**Application by Mallard Pass Solar Farm Limited for an Order Granting Development Consent
for the Mallard Pass Solar Project – project ref. EN010127**

Submission by Mallard Pass Action Group (MPAG) – unique ID ref. 20036230

Deadline 1: Suggested Locations for Site Inspection

DRAWING TITLE
Figure 6.11: Green Infrastructure Strategy Plan

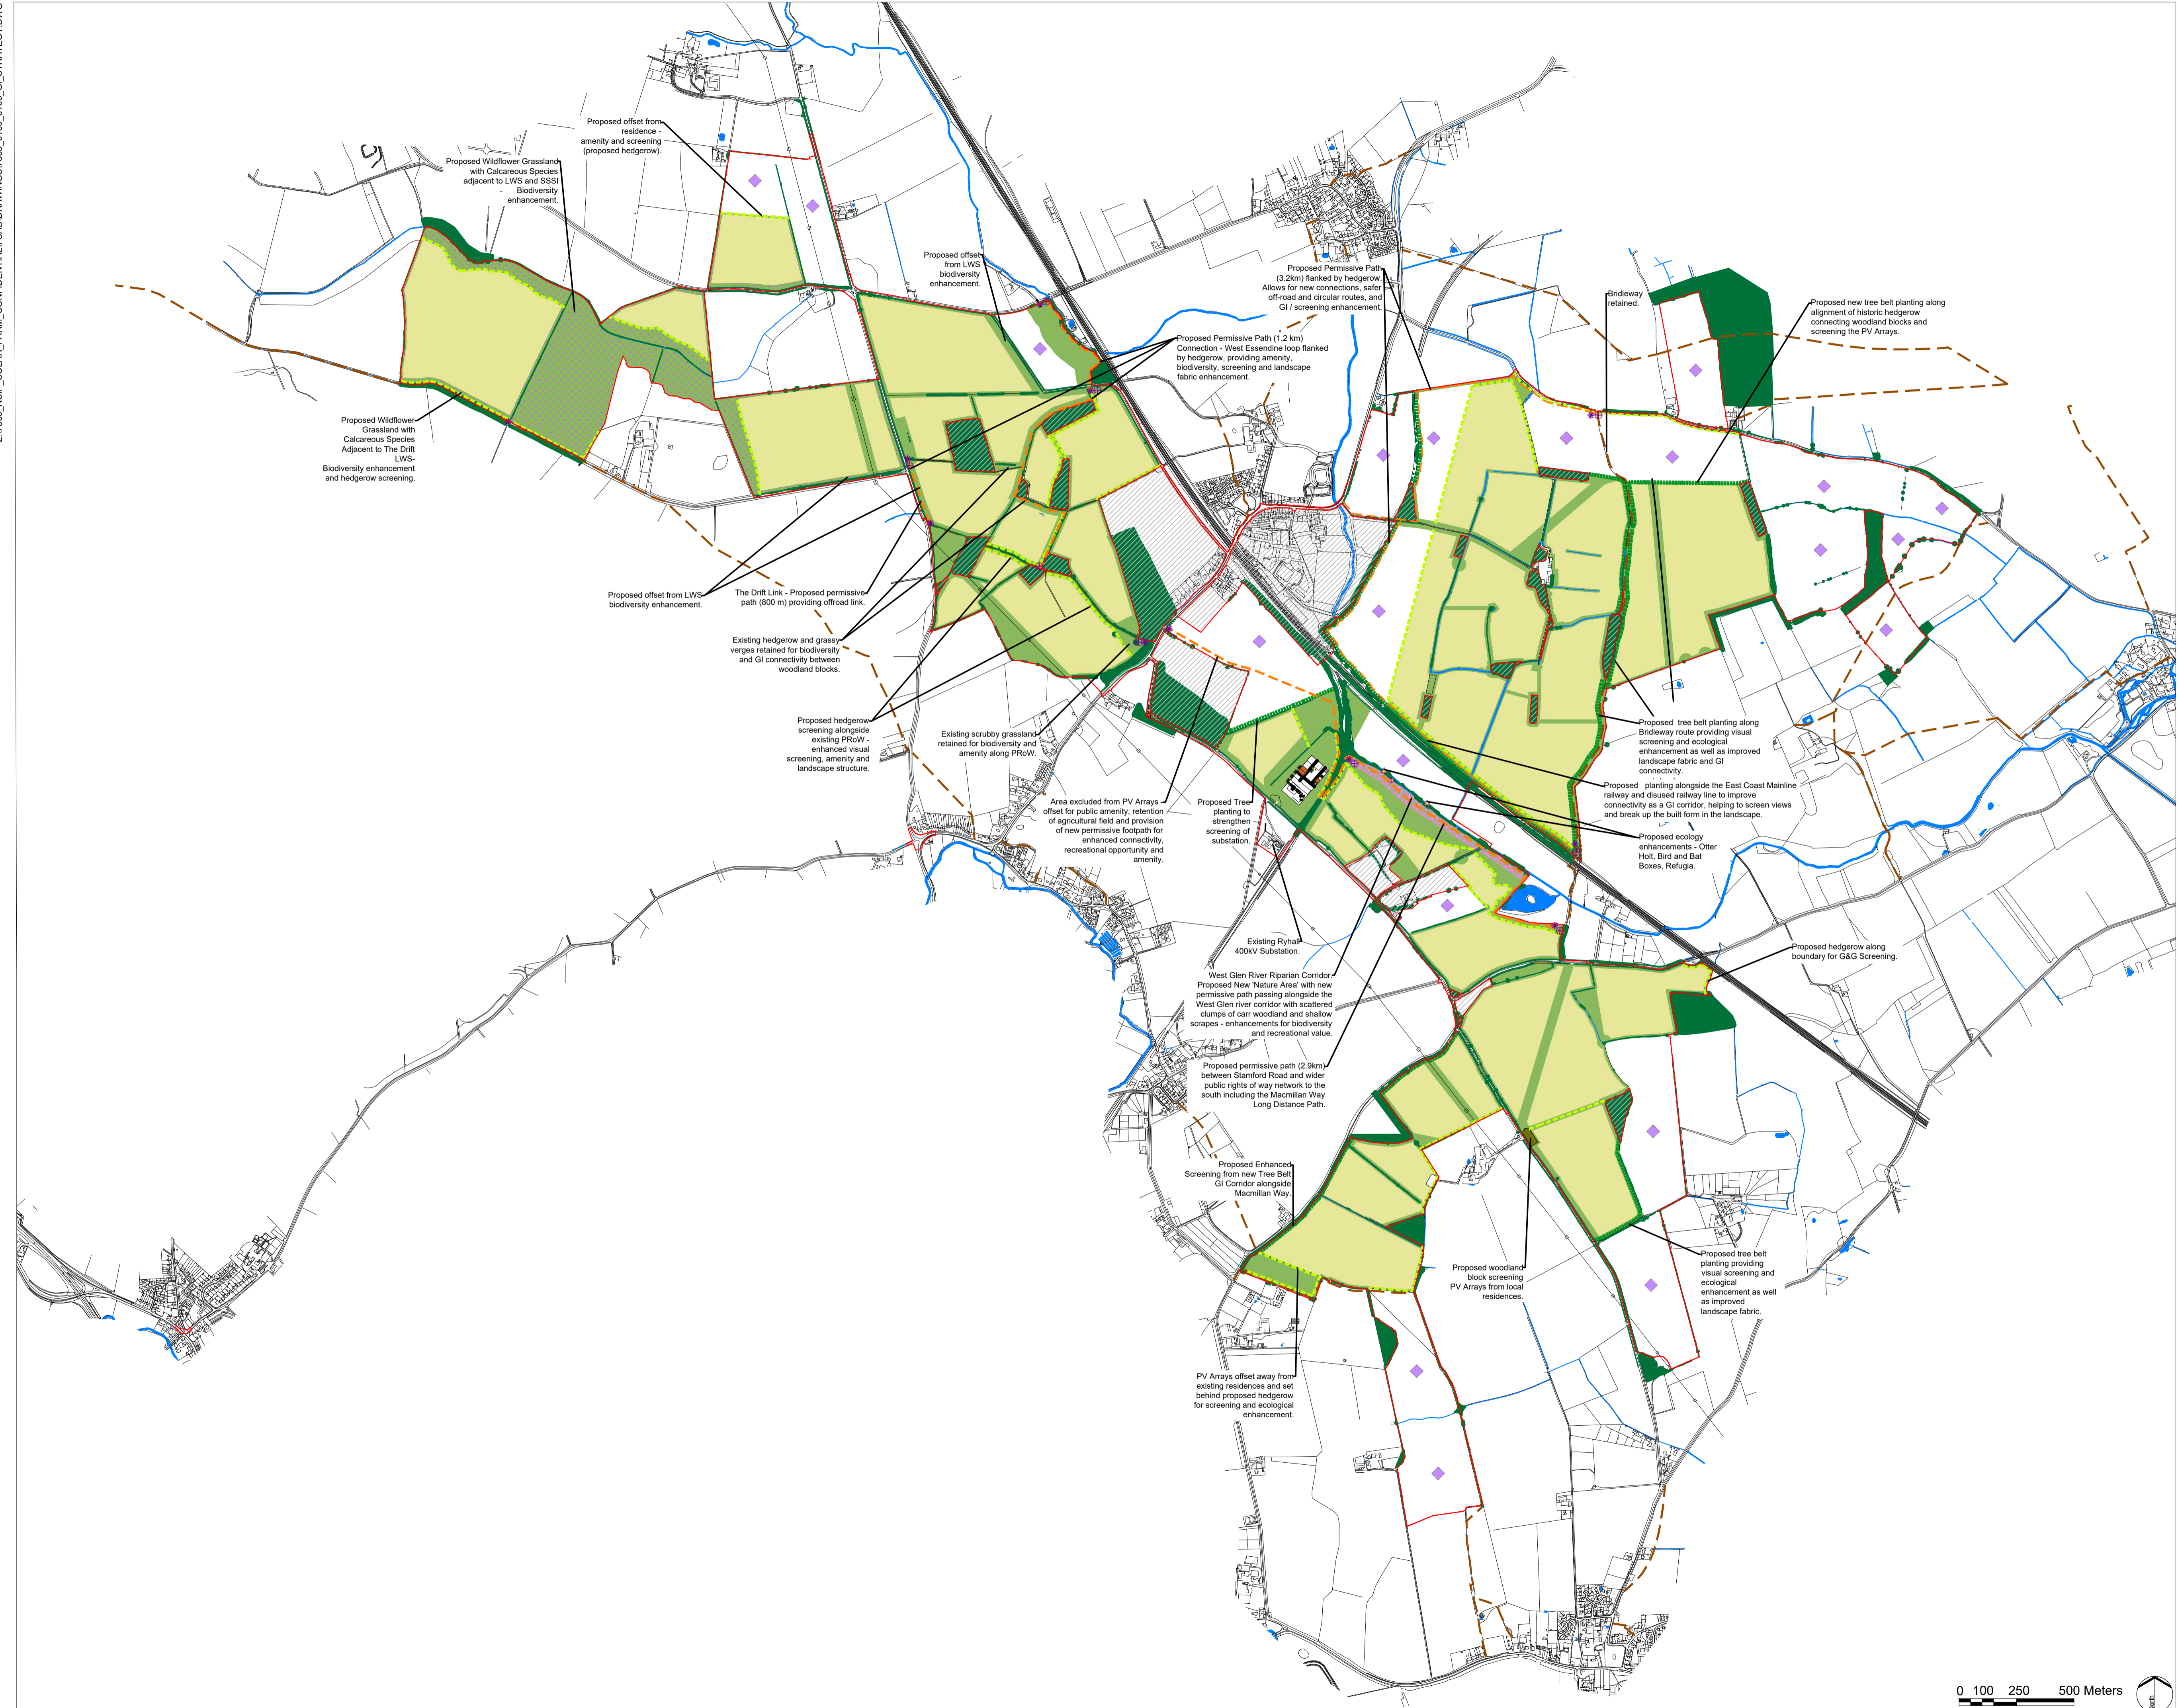
2. **Proposed permissive paths (P7-9)**. The overwhelming feedback from residents is that the permissive paths do not counteract the negative impacts of the development. This is due to locations being adjacent to solar panel fields and in some cases surrounded either side, rendering the walking experience very unpleasant. Whilst MPAG cannot walk the paths as they are on private property, it is clear to see from certain viewpoints, mapping and topography what the impact would be. It would be helpful to include these areas in a future site inspection.

Permissive Path 1

Solar field visibility – 27, 29, 30, 31, 32, 35, 21, 24, 25, 18, 18. (Due to the topography the fields detailed will be visible at some points and for some distance.)

Permissive Path 2

Solar field visibility – 27, 29, 32, 31, 30, 35, 25, 24, 21, 19, 18. (Due to the topography the fields detailed will be visible at some points and for some distance.)

Permissive Path 3

Solar field visibility – 13, 16, 10, 11, 8, 5. (Due to the topography the fields detailed will be visible at some points and for some distance.)
